An
Bord
Pleanála

Board Direction
BD-006038-20
ABP-306021-19

The submissions on this file and the Inspector's report were considered at a Board meeting held on 02/07/2020.

External Boundary Treatments
1:1500 @ A1

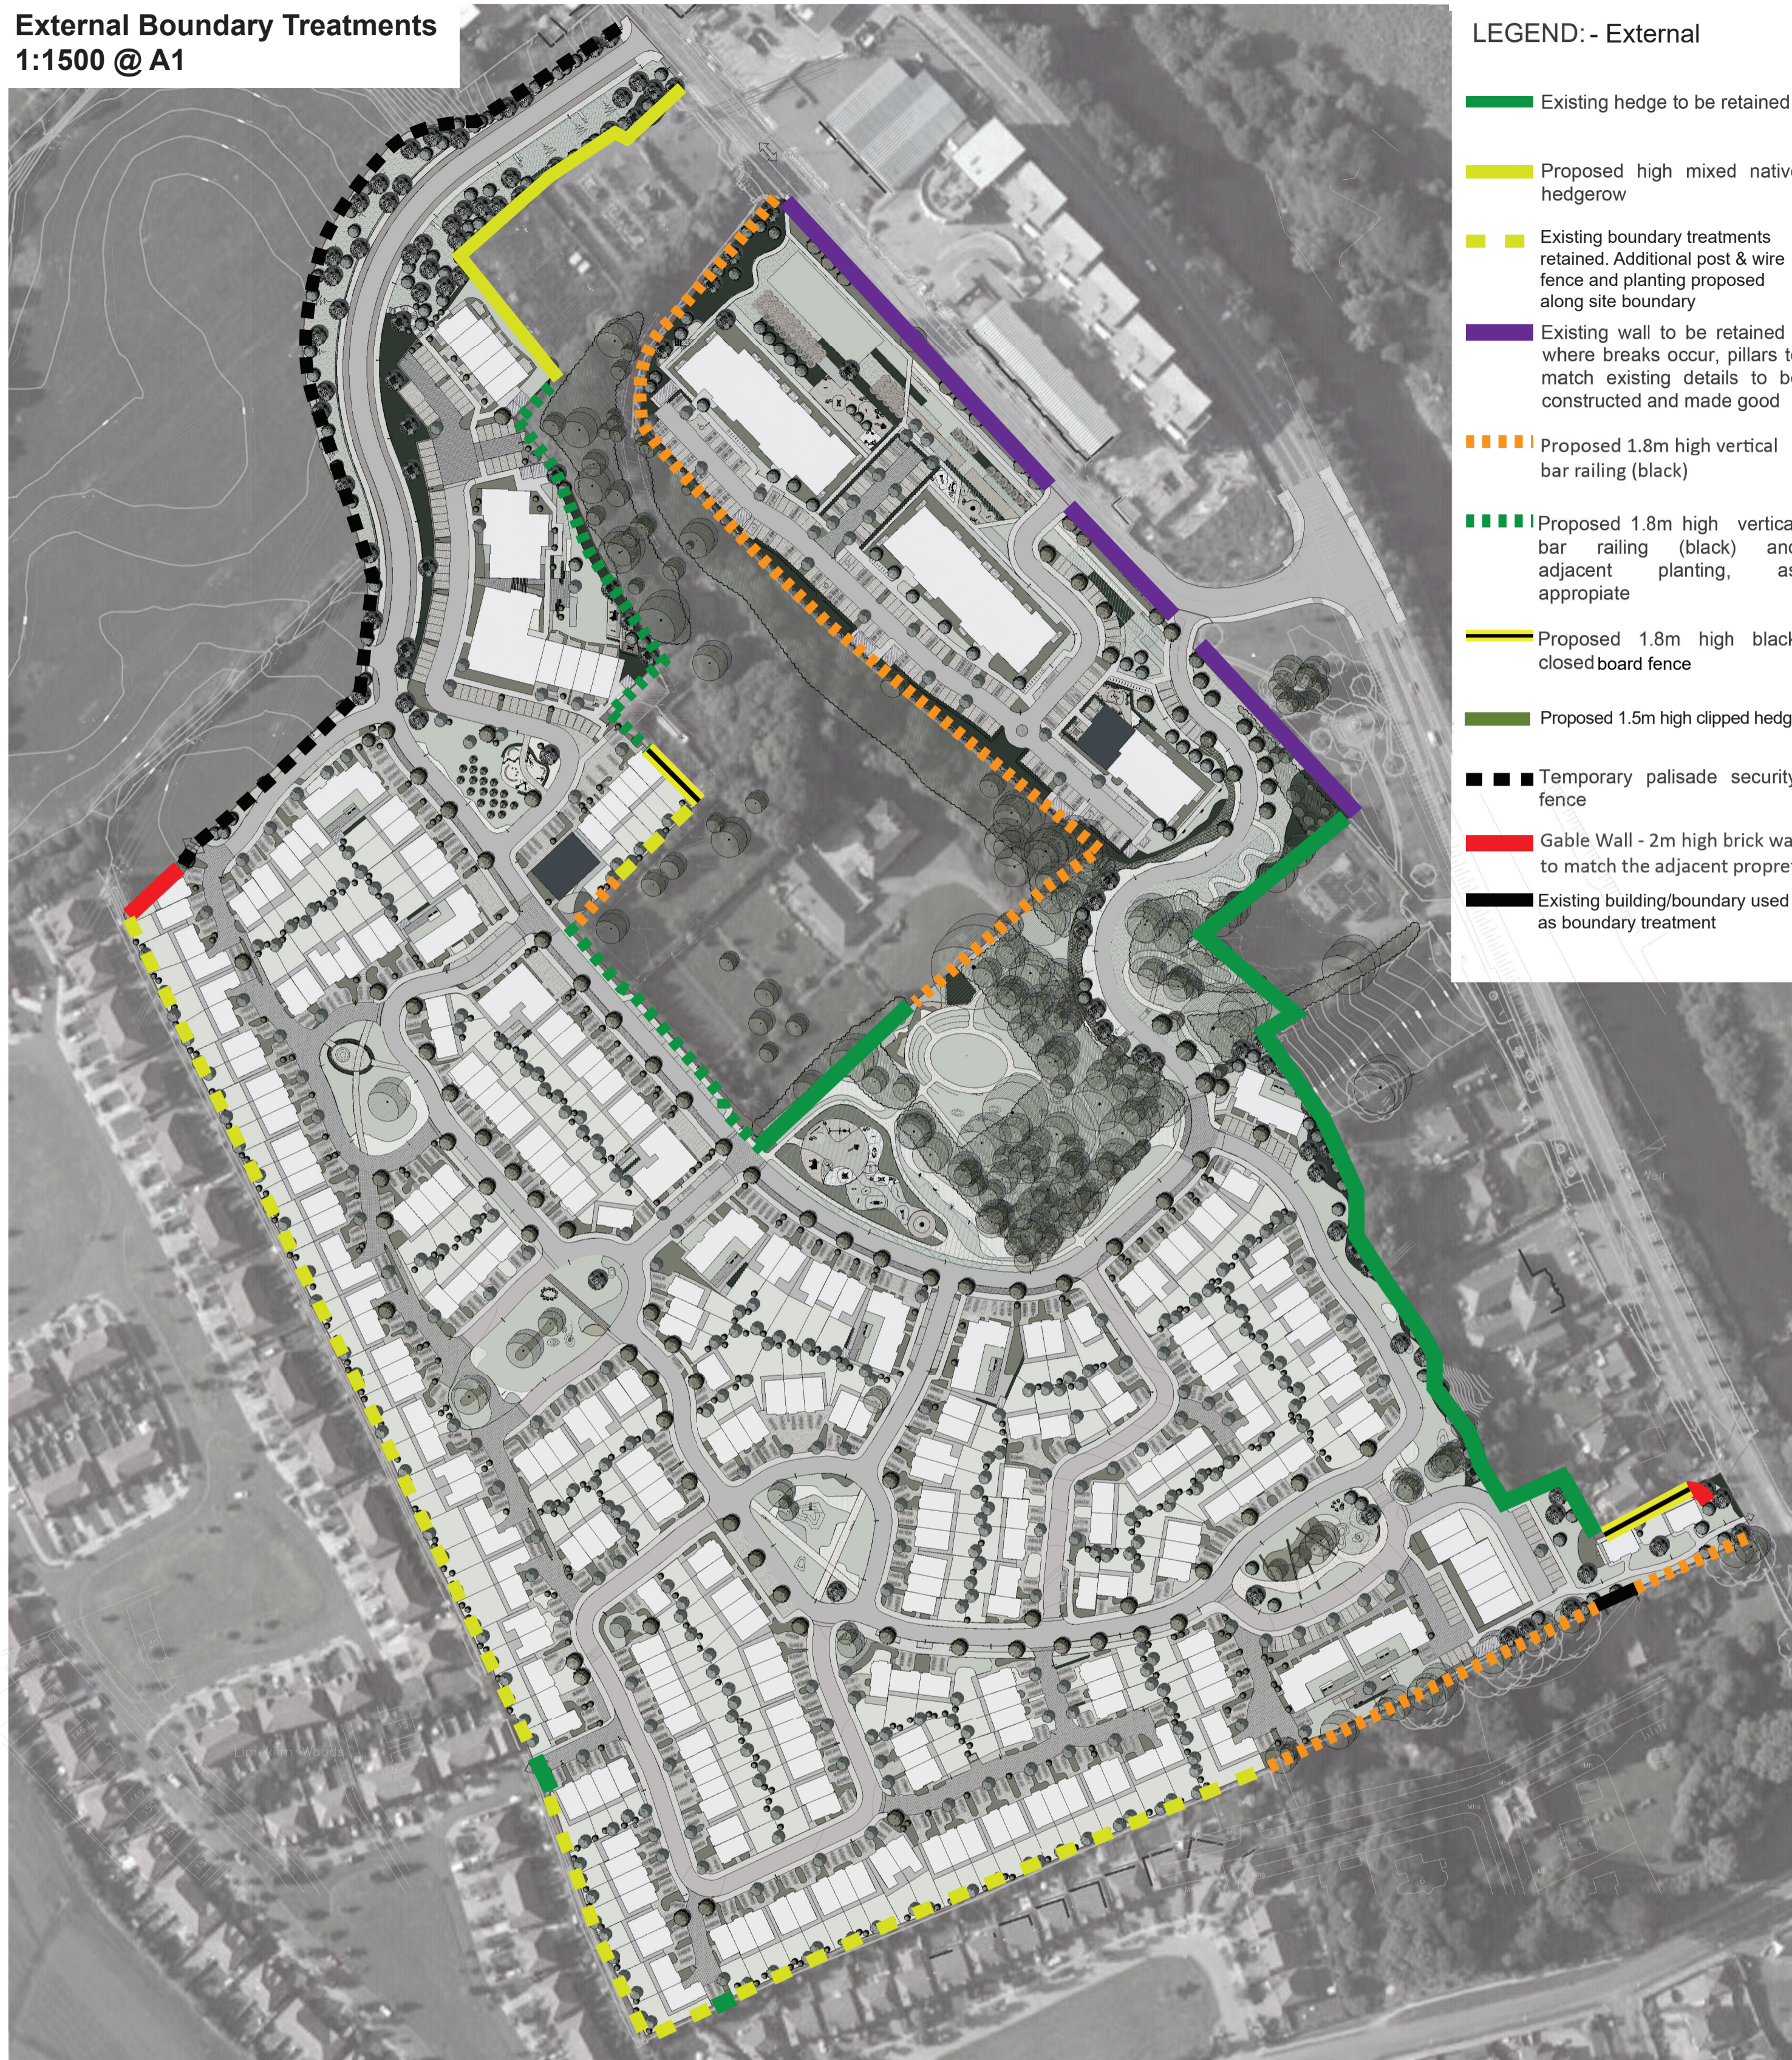
(a) Replace the proposed post and wire fence along the south and east boundary, as per DWG 18221-2-105, to include 1800mm high concrete post and plinthe fencing with vertical timber panels.

(b) Replace to the temporary palisade fencing along the northern boundary, as per DWG 18221-2-105, to include anti climb fencing.

(c) The boundary along Academy Street shall be set back to accommodate a bus priority route as identified in the Navan 2030 Public Realm and Movement Plan and to facilitate a cycle feeder route as identified in the Navan Cycle Network Plan. The boundary treatment along Academy Street shall be similar to the existing boundary treatment proposed as per DWG 18221-2-105, with the setback agreed with the Planning Authority.

(h) Submission of detailed design of a proposed gate for the pedestrian access points to replace the retention of the existing hedge as per DWG 18221-2-105.

Revised drawings showing compliance with these requirements shall be submitted to, and agreed in writing with, the planning authority prior to commencement of development. In default of agreement, the matter(s) in dispute shall be referred to An Bord Pleanála for determination.
